Ribble Valley Borough Council  
Housing & Development Control

Application no: **3/2021/1146**

Address: **Lyndon Northcote Road Langho BB6 8BG**

Proposal: **Single storey rear extension and front access ramp**

**A1.2**

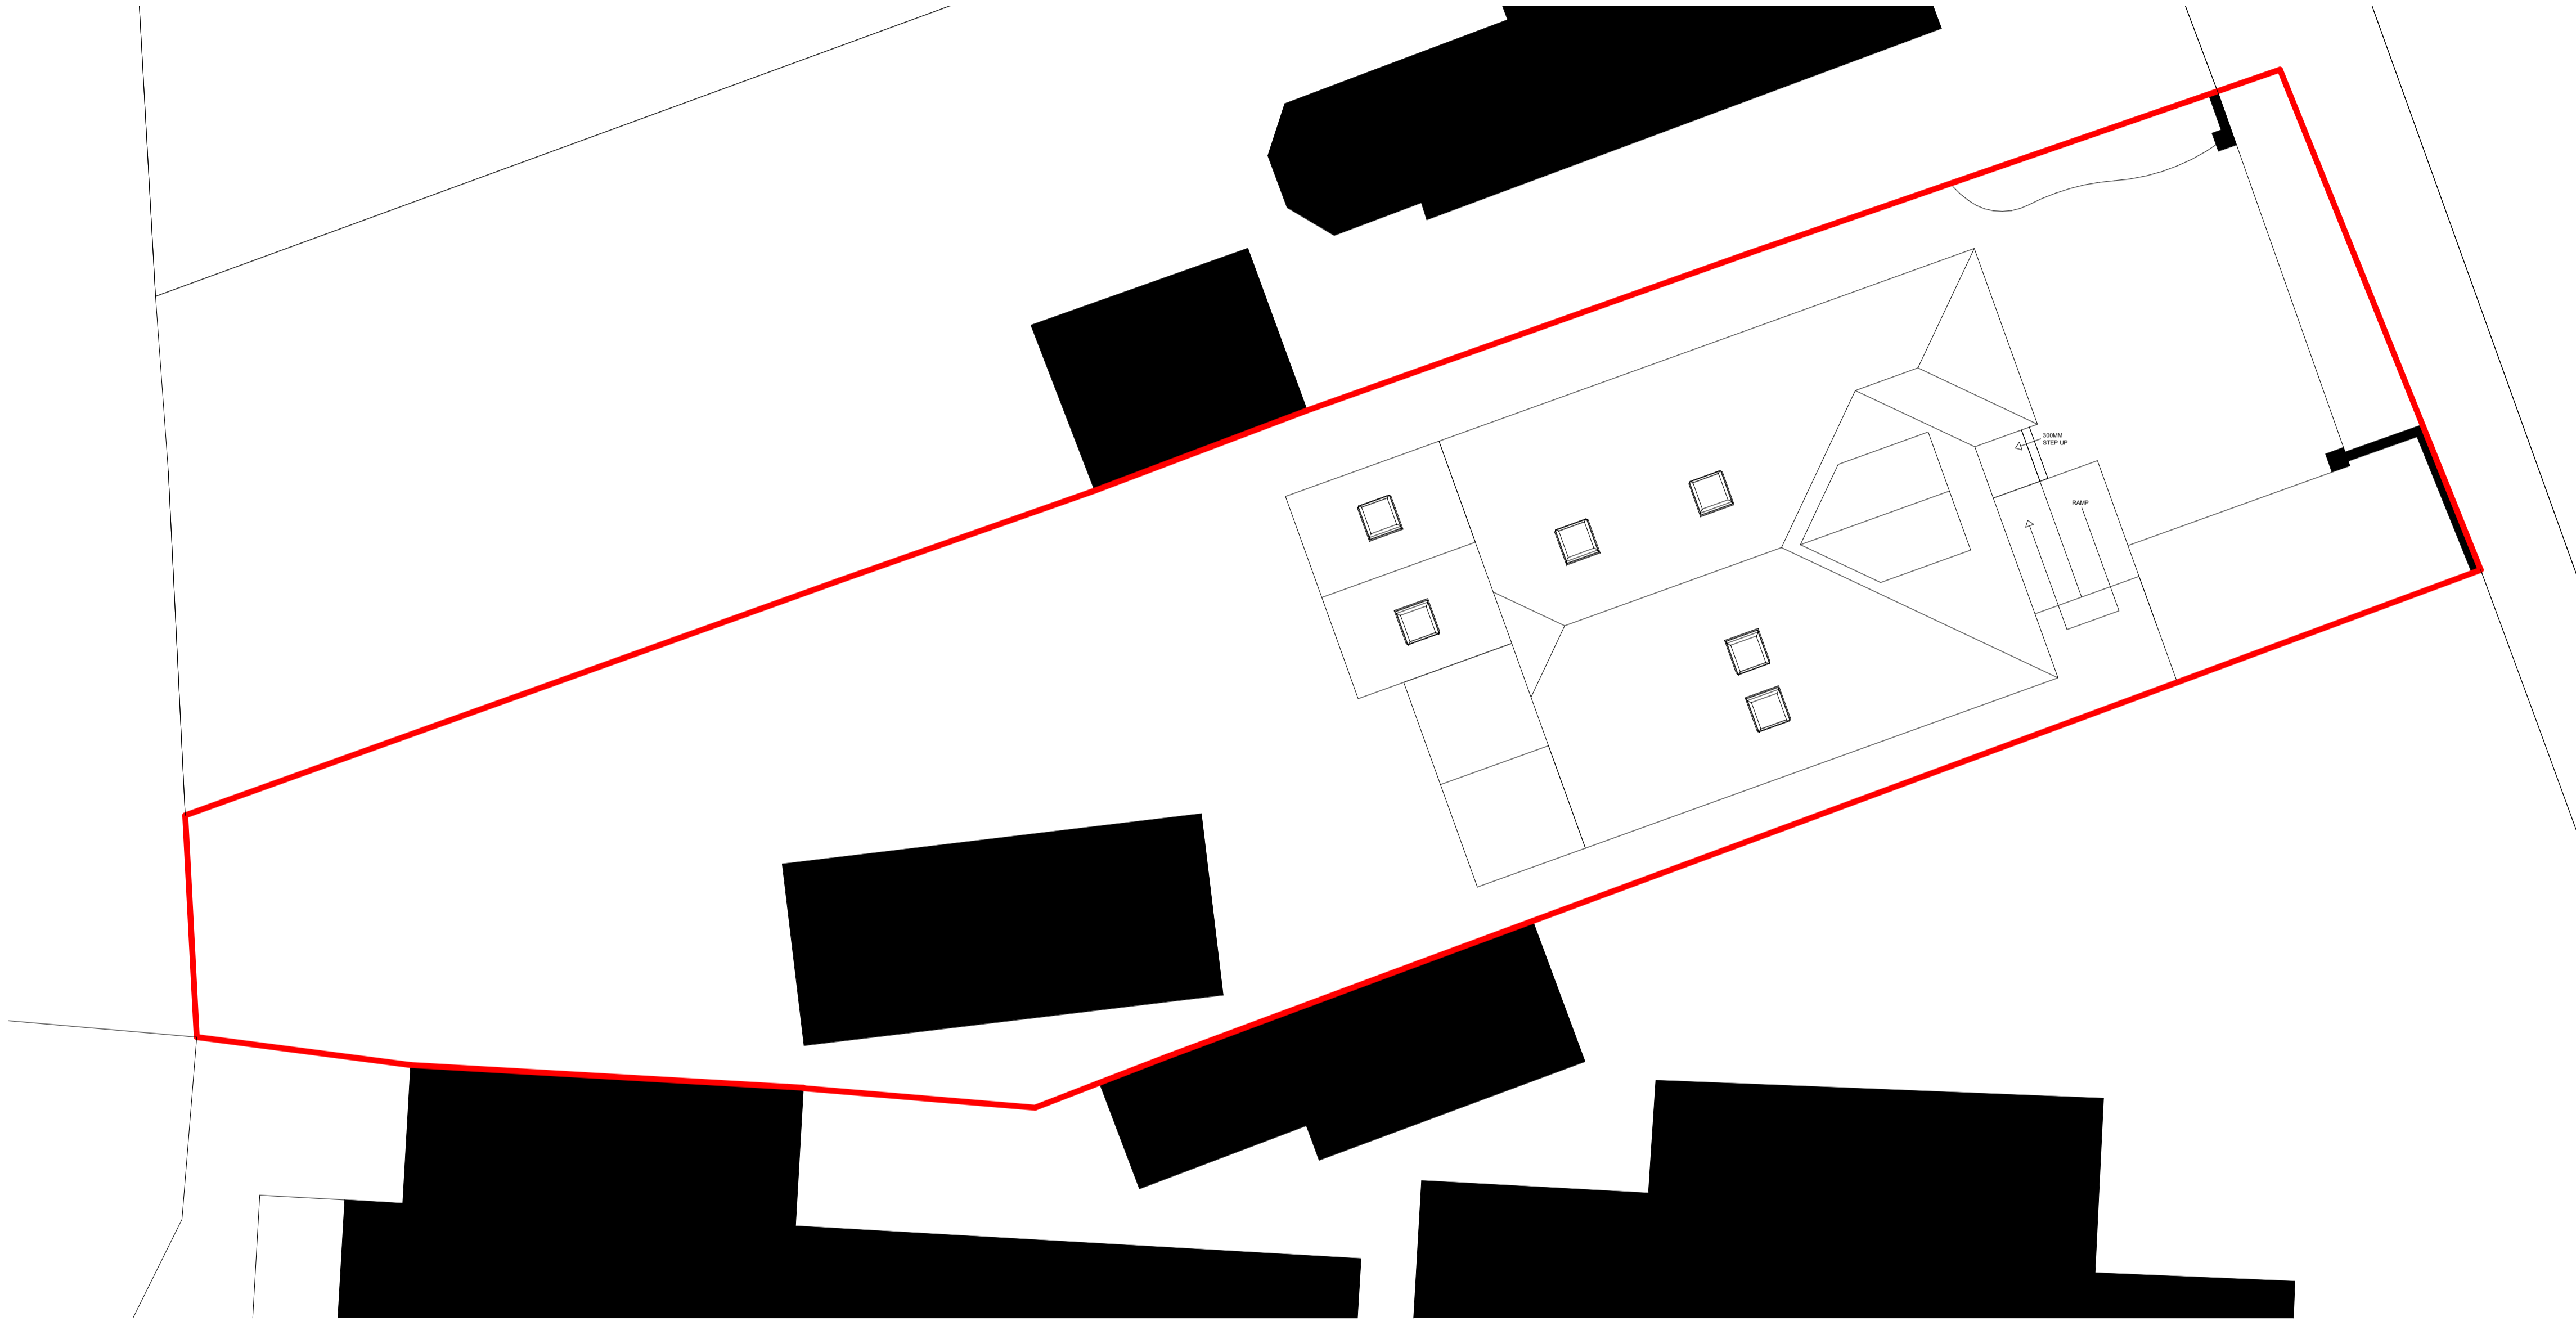
The LHA have reviewed Peter Hitchen drawing number A1.2 titled "Proposed Site Plan" and understands that the existing access, which is accessed off Northcote

Road, a C classified road subject to a 30mph speed limit, will be widened to a length of approximately 8m.

The LHA are satisfied the access width complies with the LHAs guidance and so have no objection to the widening of the access. The LHA do advise the Applicant, however, that they will have to apply for a dropped kerb application when widening the access. All the information can be found in the Informative section.

1.No part of the development hereby permitted shall be occupied until such time as the access arrangements shown on Peter Hitchen drawing number A1.2 have been implemented in full.

3. The development hereby permitted shall not be occupied until such time as the access drive (and any turning space) has been surfaced with tarmacadam, or similar hard bound material (not loose aggregate) for a distance of at least 5 metres behind the highway boundary and, once provided, shall be so maintained in perpetuity.
